From  
The Member Secretary,  
Chennai Metropolitan  
Development Authority,  
No.1, Gandhi Irwin Road,  
CHENNAI -600 008.

Letter No. A2/3541/2003

Dated: 03-06-2003

Sub: CMDA - Planning Permission - Construction  
of Residential Building at Plot No.41(pt),  
S.No.178, 181/2, Perundhalaivar Kamarajar  
Nagar, Perungudi Village - Development  
charges and other charges to be remitted -  
Regarding.

PLAN SHOWING THE PROPOSED CONSTRUCTION OF RESIDENTIAL BUILDING AT PLOT NO. 41P/5 NO. 178, BICMDA CHANNEL KAMARAJAR PERUNGUDI VILLAGE, TAMBARAM, KUNCHIPURAM DISTRICT, A.P. SCALE 1" = 8' 0"

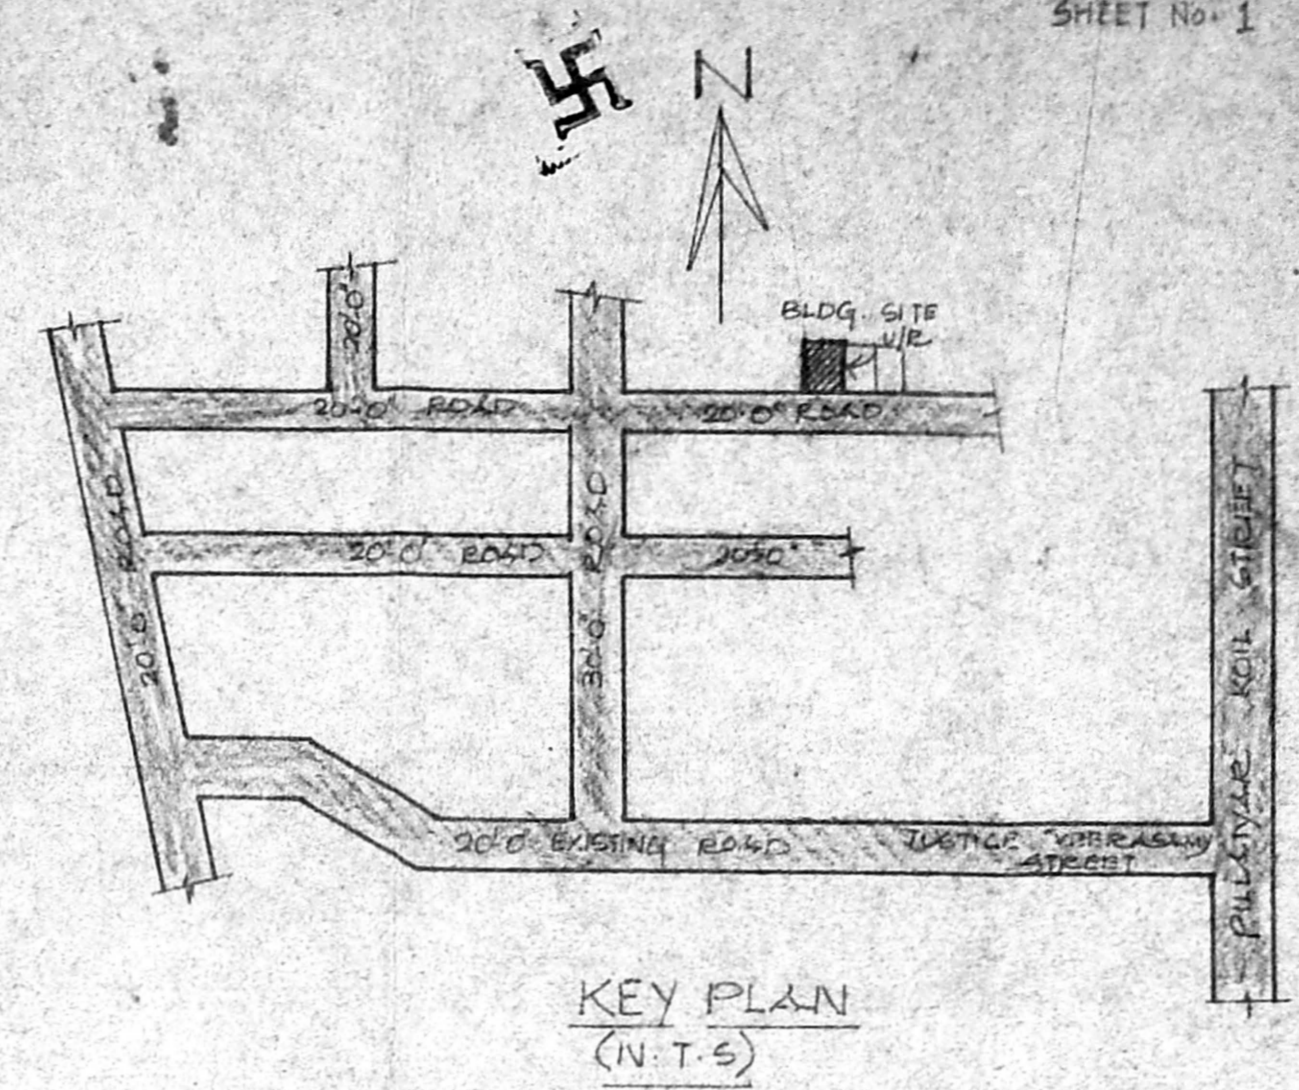
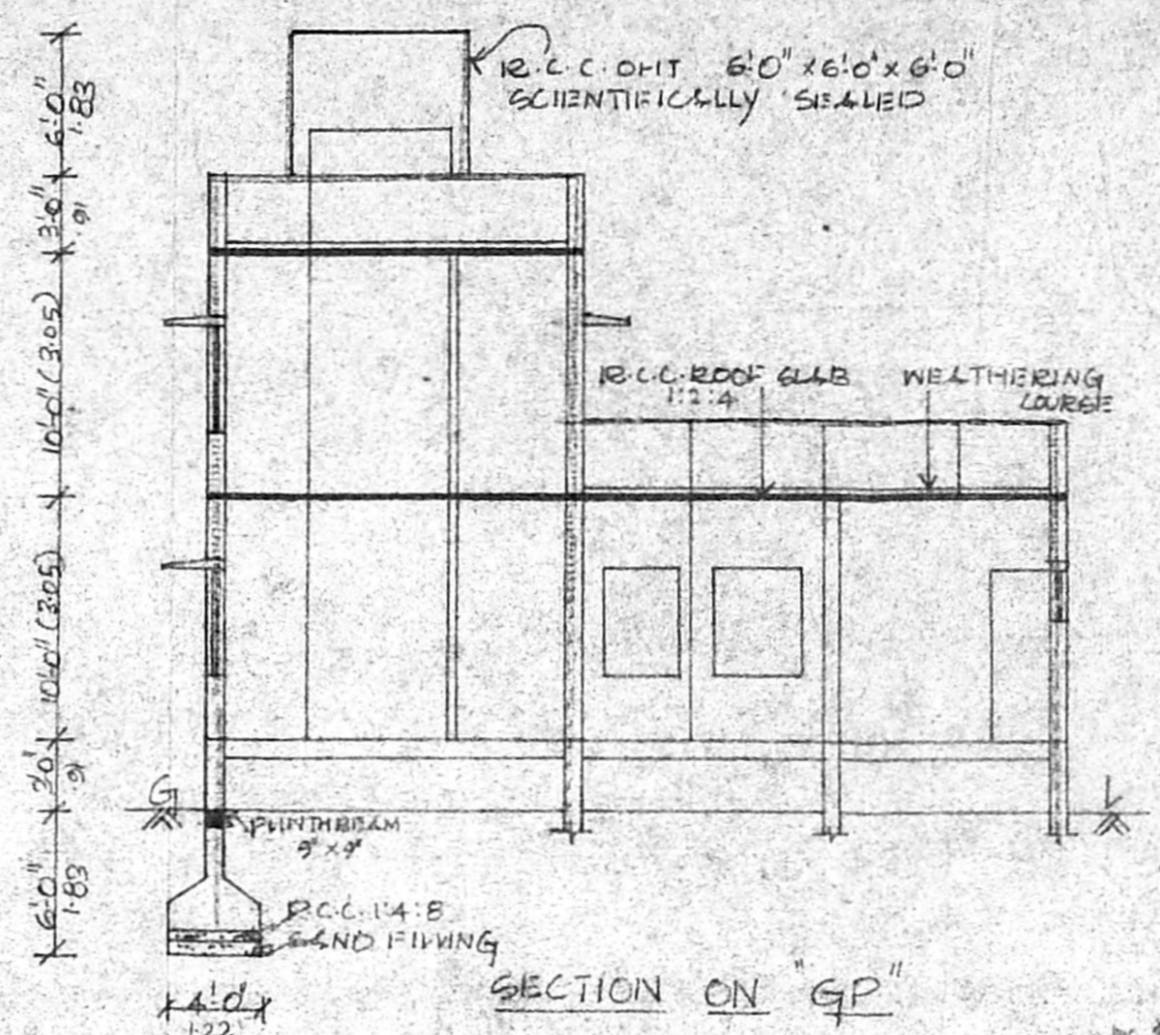
- a) Rain water conservation regulations stipulated by CMDA should be adhered to strictly.
- b) 5 copies of revised plan by
- i) deleting the residuary plot details and furnishing it in a separate sheet.
  - ii) One parking lot to be indicated.
  - iii) Elevation to be drawn correctly (not as isometric view).
